From: [Pat Deneen](#)
To: [Zach Torrance-Smith](#)
Subject: Re: BL-26-00004 Central WA Land Group - Additional Information
Date: Tuesday, April 14, 2026 12:35:36 PM
Attachments: [Subdivision Guarantee.pdf](#)

I am reaching out regarding the Boundary Line Adjustment that was submitted 4/10/2026 for the two properties at 2516 W. Dry Creek Rd.

EXHIBIT 4 ADJUSTED PARCELS

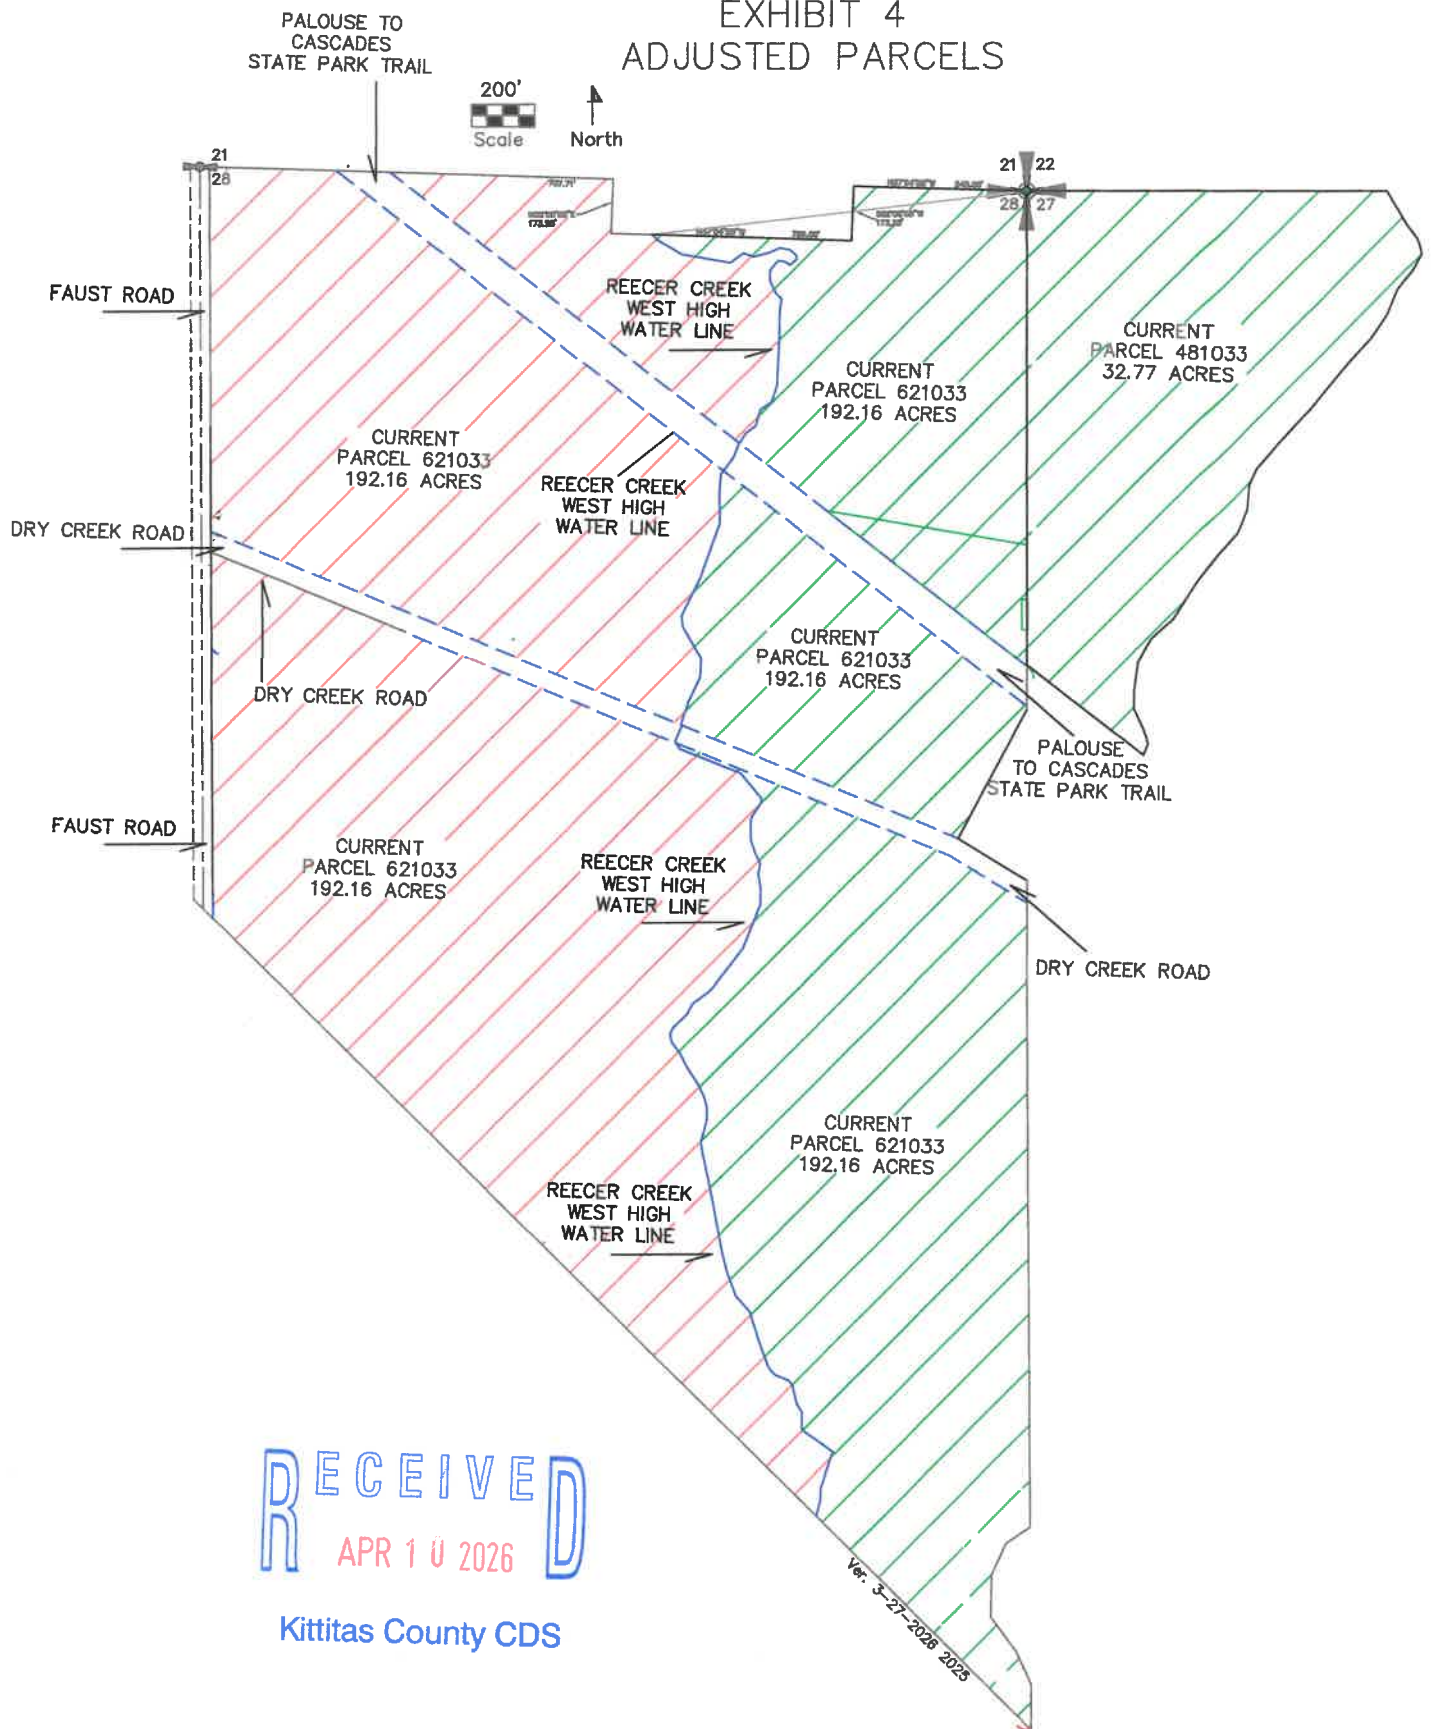
- The title report appears to be missing, all BLA's require a Certificate of Title that has been issued within the previous 120 days.
- Well/Septic information – Documentation that was turned in states “see map” for well(s) present on the property, but no submitted maps show the well(s) on-site. The sewage element of the project is also not addressed by the submitted materials.

The septic systems have been abandoned.
